QUICK QUACK CONSTITUTION  
GRADING PLAN  
2437 MARKSHEFFEL ROAD COLORADO SPRINGS, CO 80951

SHEET: C-2  
DATE: Jan 31, 2019

QUICK QUACK CONSTITUTION SWPPP PLAN

SHEET:
C-2.1
DATE: Jan 31, 2019

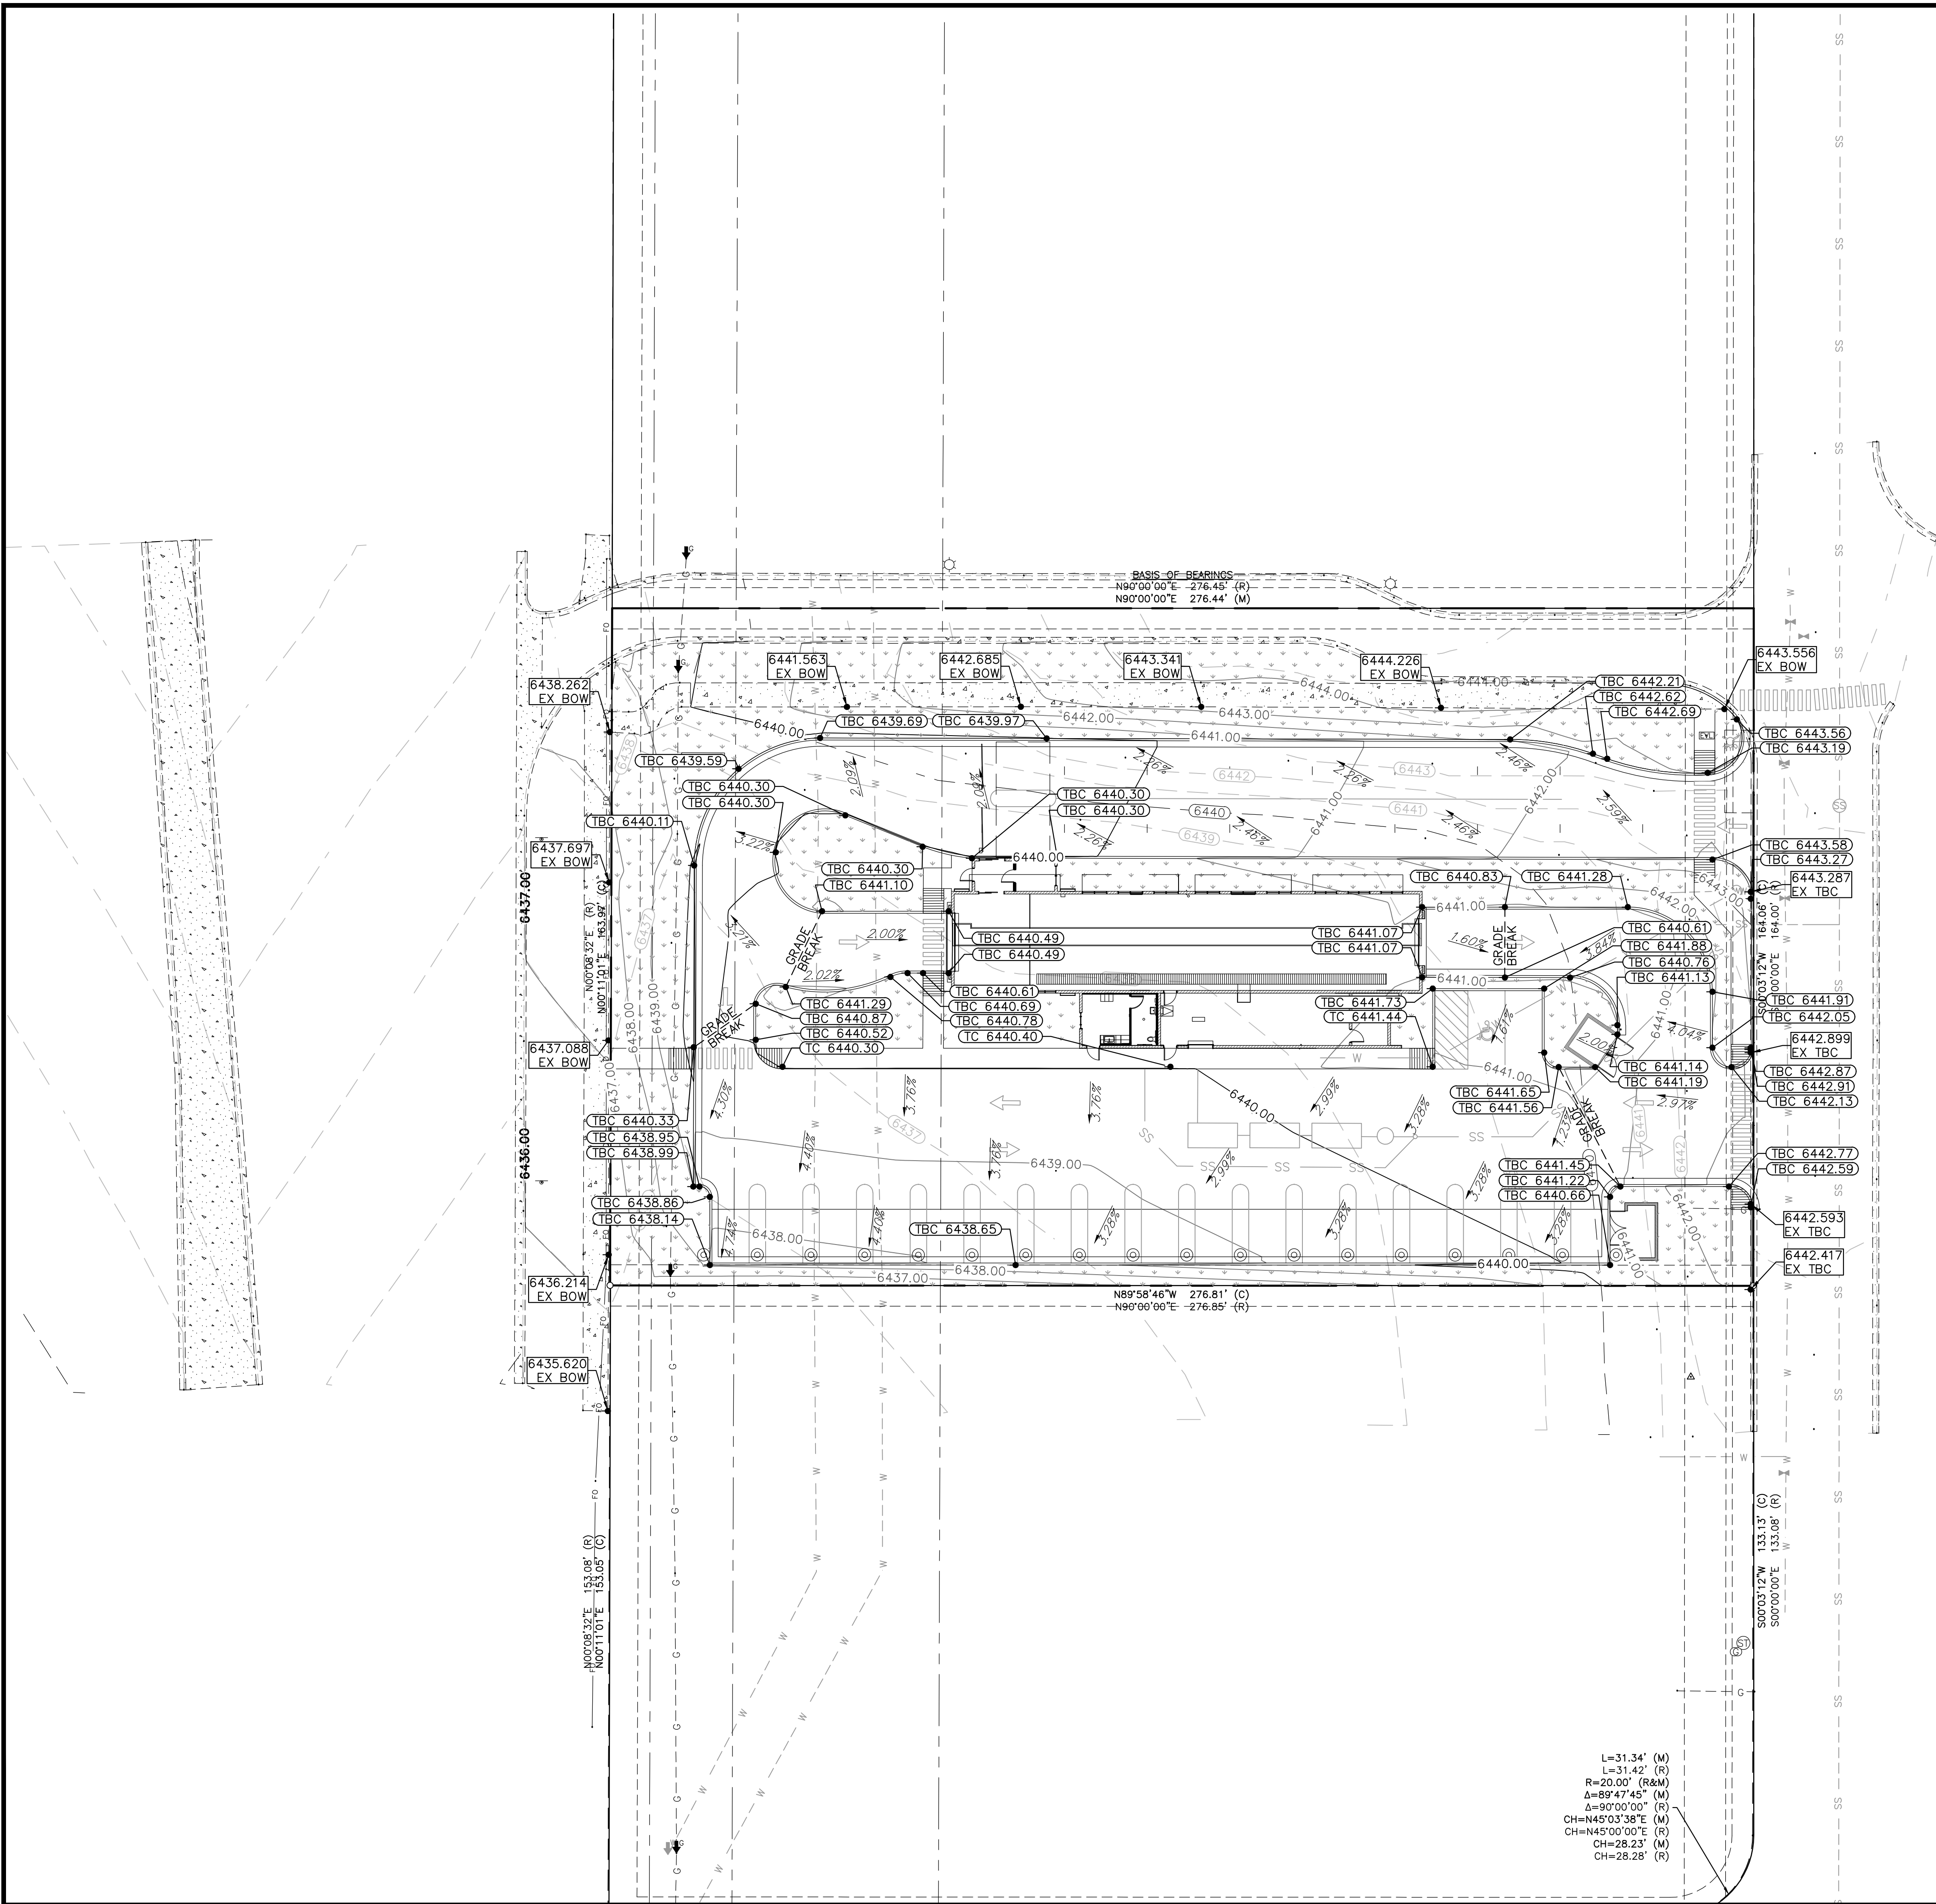
Disturbance is over an acre. Submit as a standalone Grading and Erosion Control Plan.  
1. Provide a cover sheet with the standard signature blocks, vicinity map, point of contacts, sheet index, etc. Title on coversheet to state "Grading and Erosion Control Plan for [project name]"  
2. See the attached checklist for missing items.

Show the proposed and existing storm sewer inlet and stormline. Provide construction level detail. ie. provide inlet information (type, size, and inverts) and pipe information (size, material, and slopes).

Draw and label the limits of construction.

Remove the design note.  
The design engineer preparing the plan is responsible for familiarizing themselves with all current accessibility criteria and specifications. The grading plan prepared by the engineer should reflect the applicable ADA design standards. El Paso County does not assure compliance with the ADA or any regulations or guidelines enacted or promulgated under or with respect to such laws.

Label easements (include recording reference). Update line type. The legend notes this line type as lot lines.

Provide finished floor elevation.

Advisory comment only: cross slope for a pedestrian access route must be less than 2% per ADA

SHEET:
C-6
DATE:
Jan 31, 2019

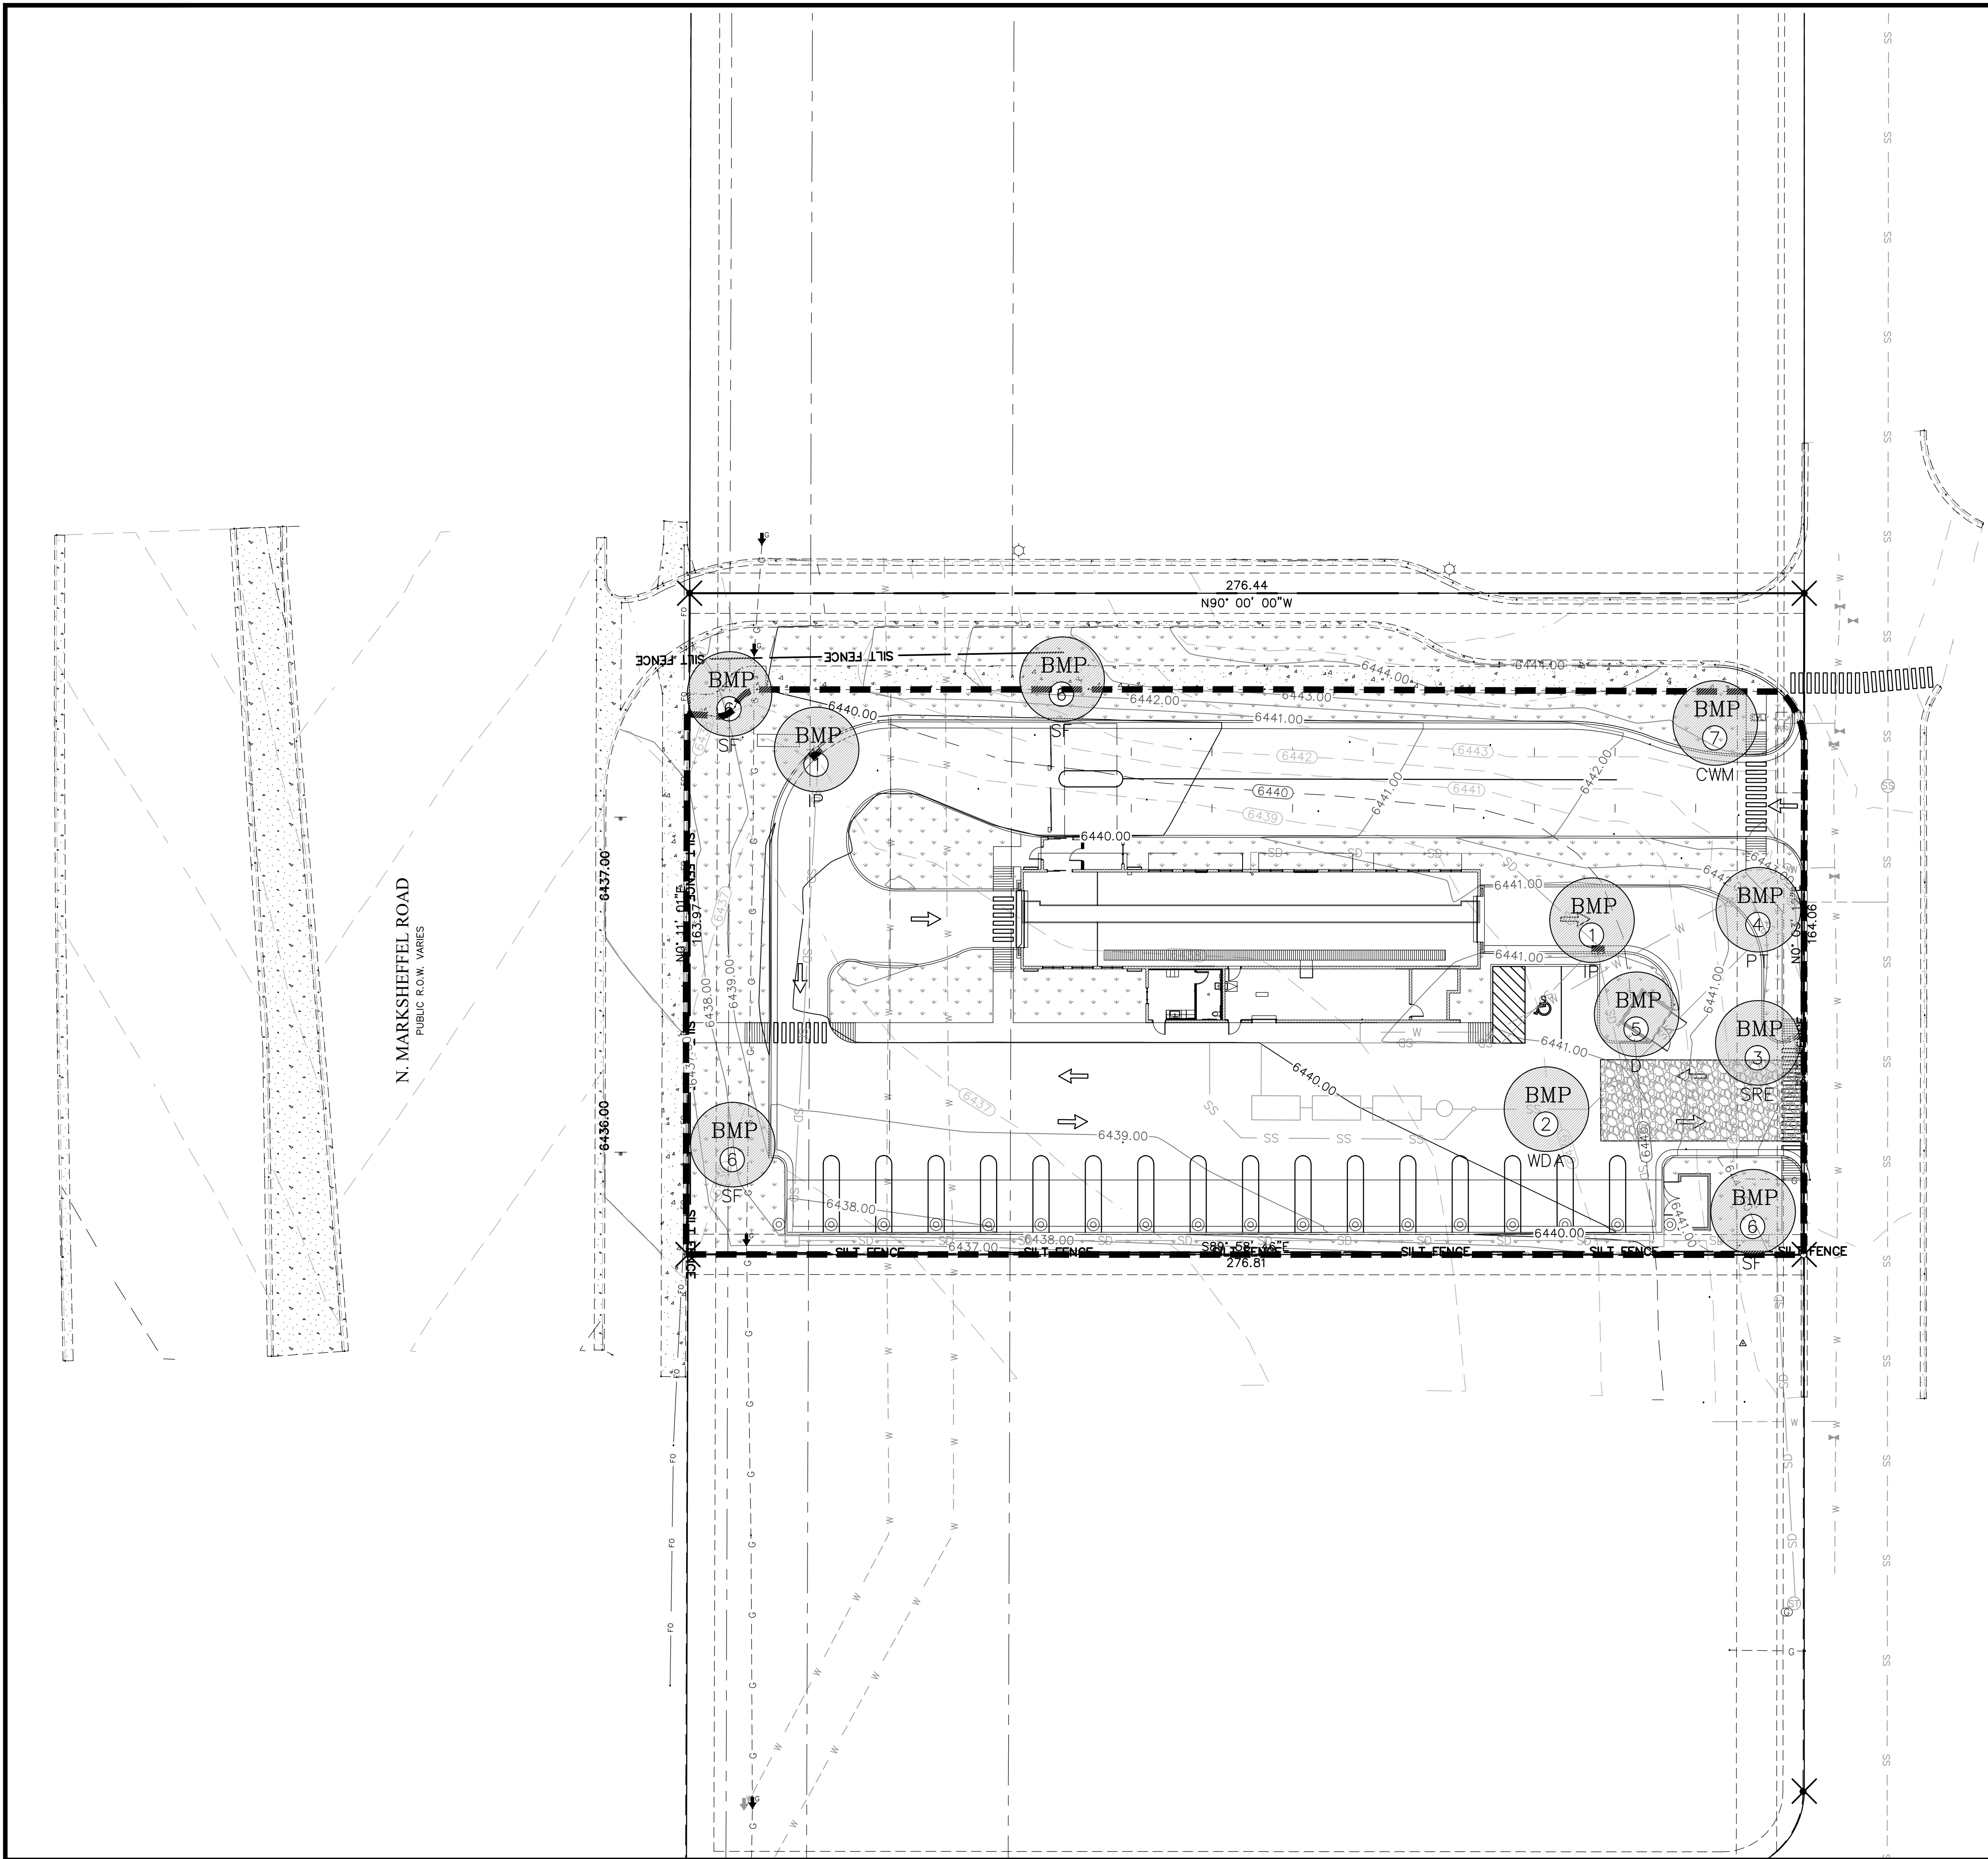
Provide inlet protection

Revise label to match the names on the detail sheet for the VTC and CWA.

Identify the staging area.

Provide a barricade if this is not used as a construction entrance or provide vehicle tracking control.

Replace title as "Erosion Control Plan"
